**Bent Grass Residential Filing No. 2**  
**Traffic Impact Study**  
PCD File No.: SF-1914  
(LSC #194460)  
January 24, 2020

# Summary of Comments on Working File - LSC Responses to County TIS Redline Comments 3-13-20.pdf

SUBJECT: SF-19-014– Bent Grass Residential Filing No. 2  
Third Submittal  
**(w/ LSC Responses – 4/19/2020)**

Figure 10  
**Year 2040 Total Traffic, Lane  
 Geometry, Traffic Control and Level of Service**  
 Bent Grass Residential Filing No 2 (LSC #194460)

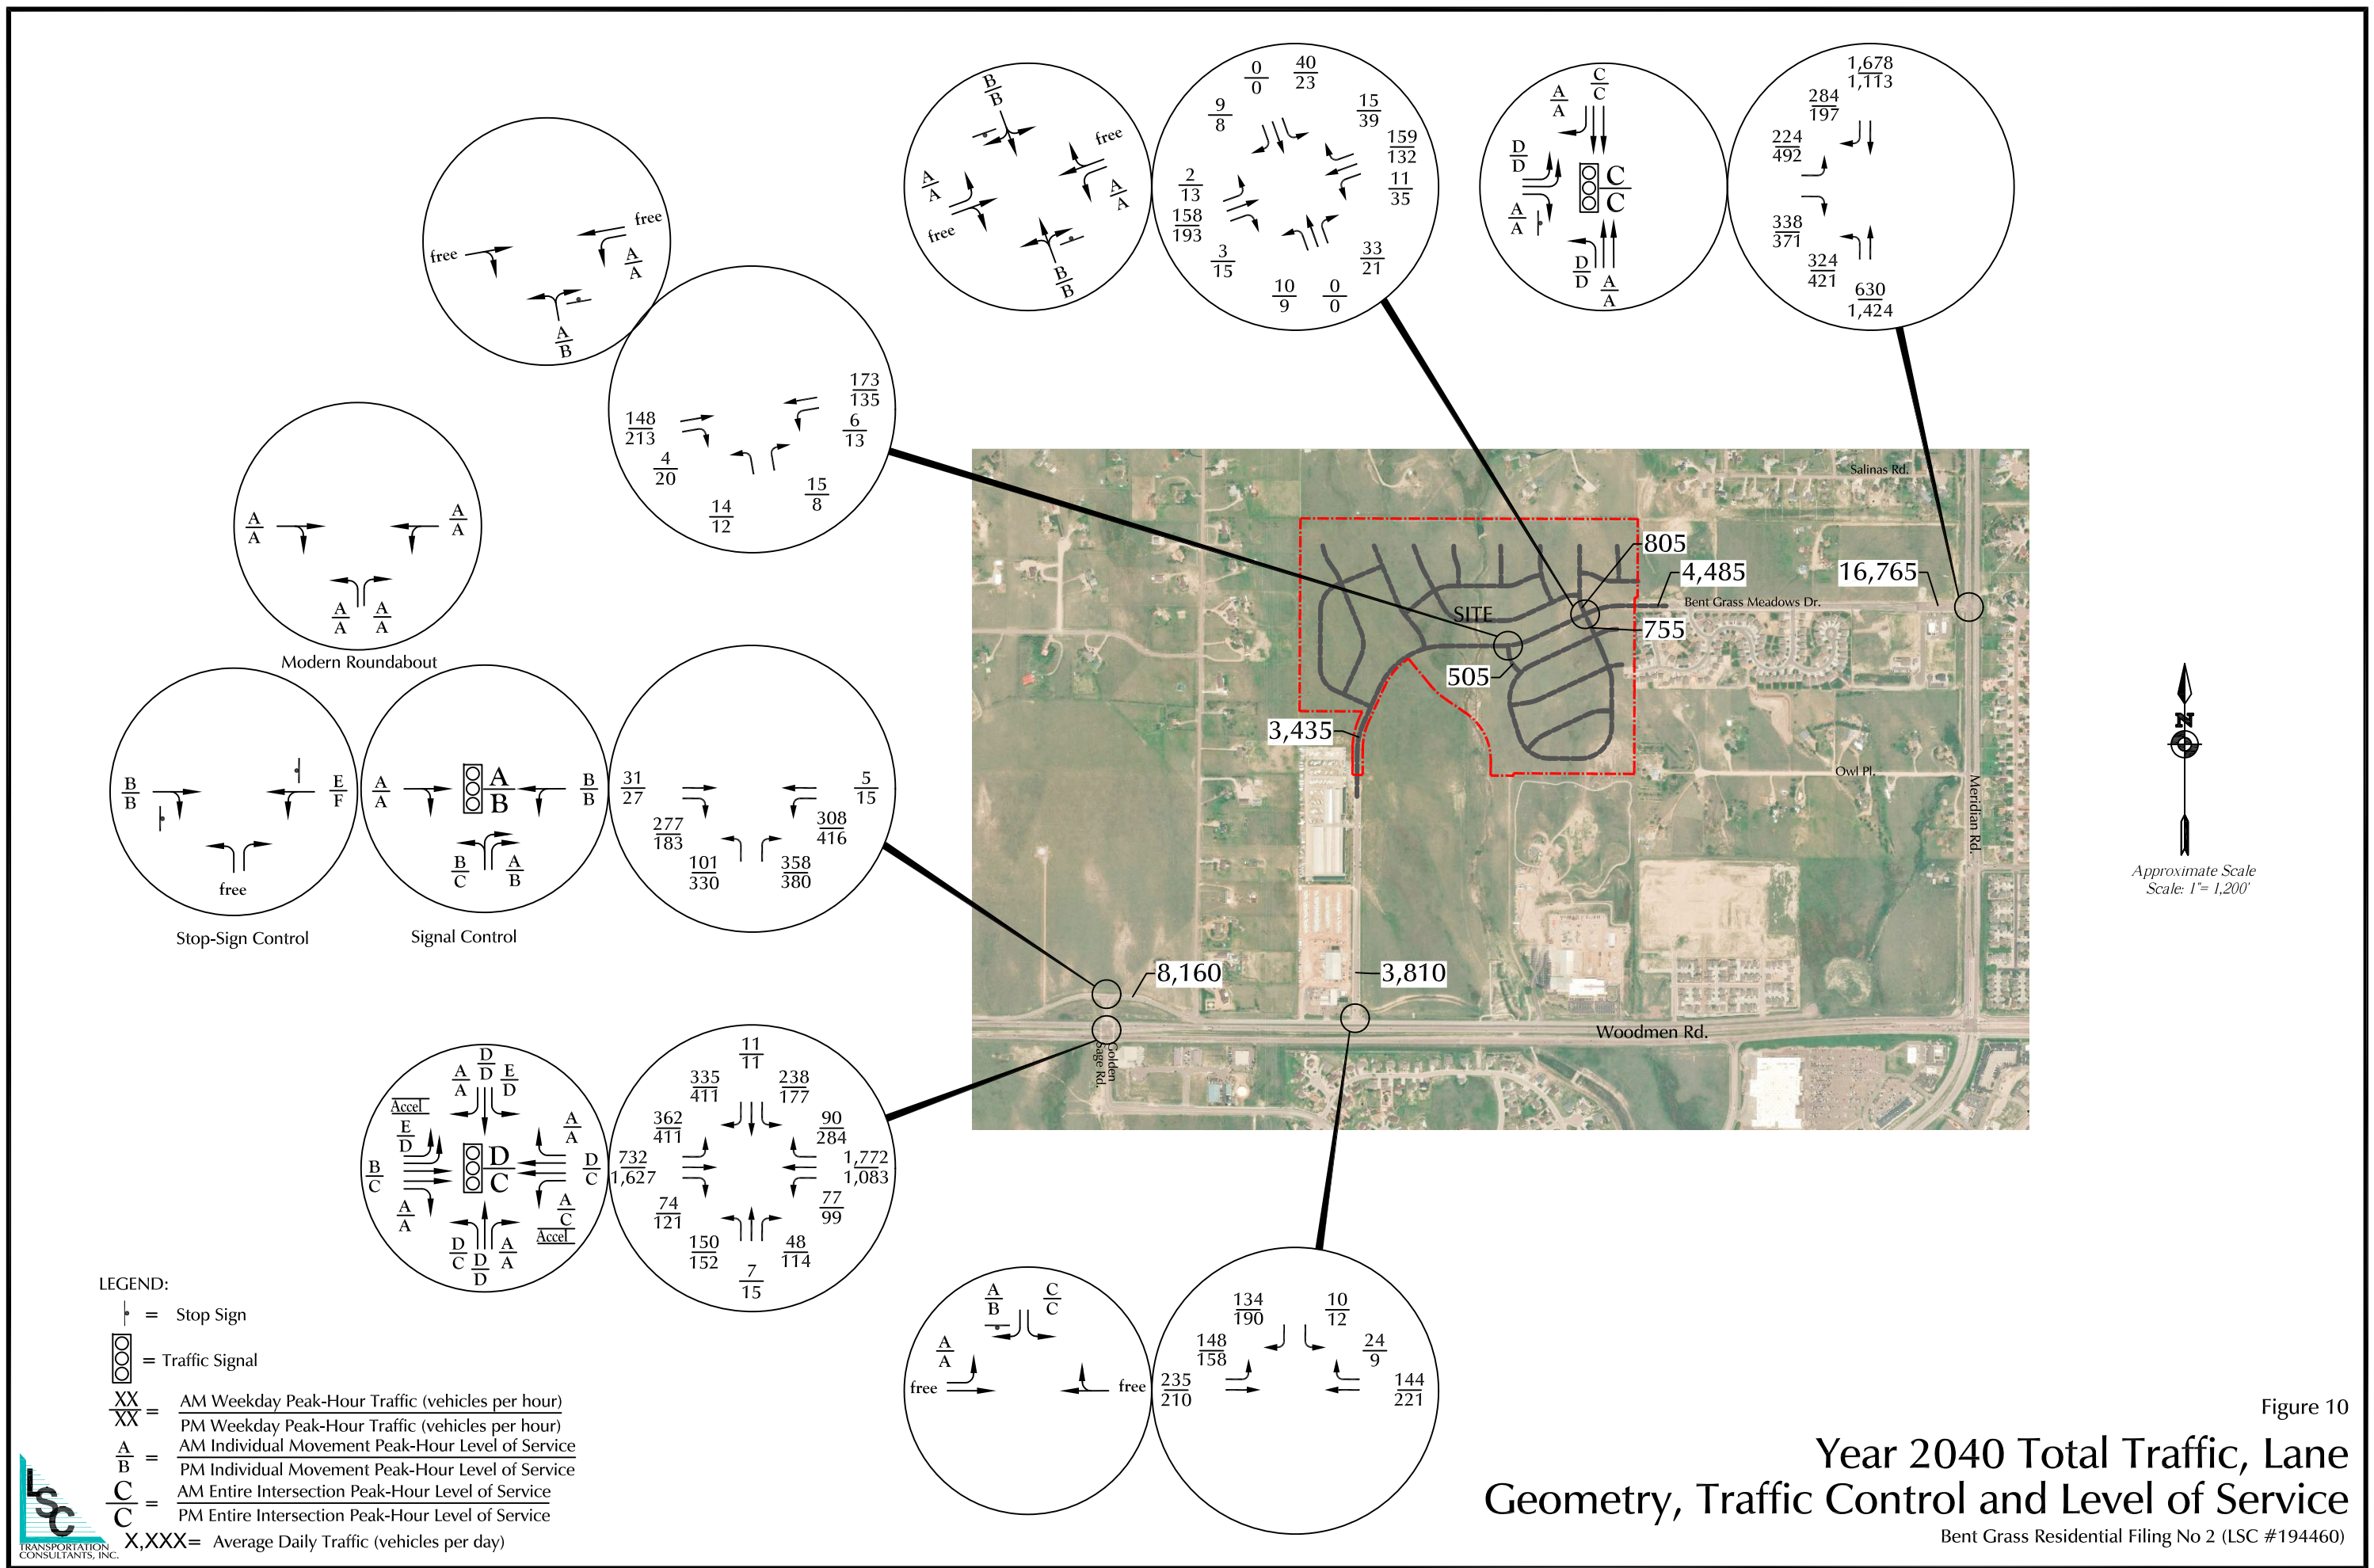
Add a note addressing this potential access. (Would westbound traffic be likely to use this to access Bent Grass Meadows Drive?)

LSC Response: This has been added to the TIS as requested.
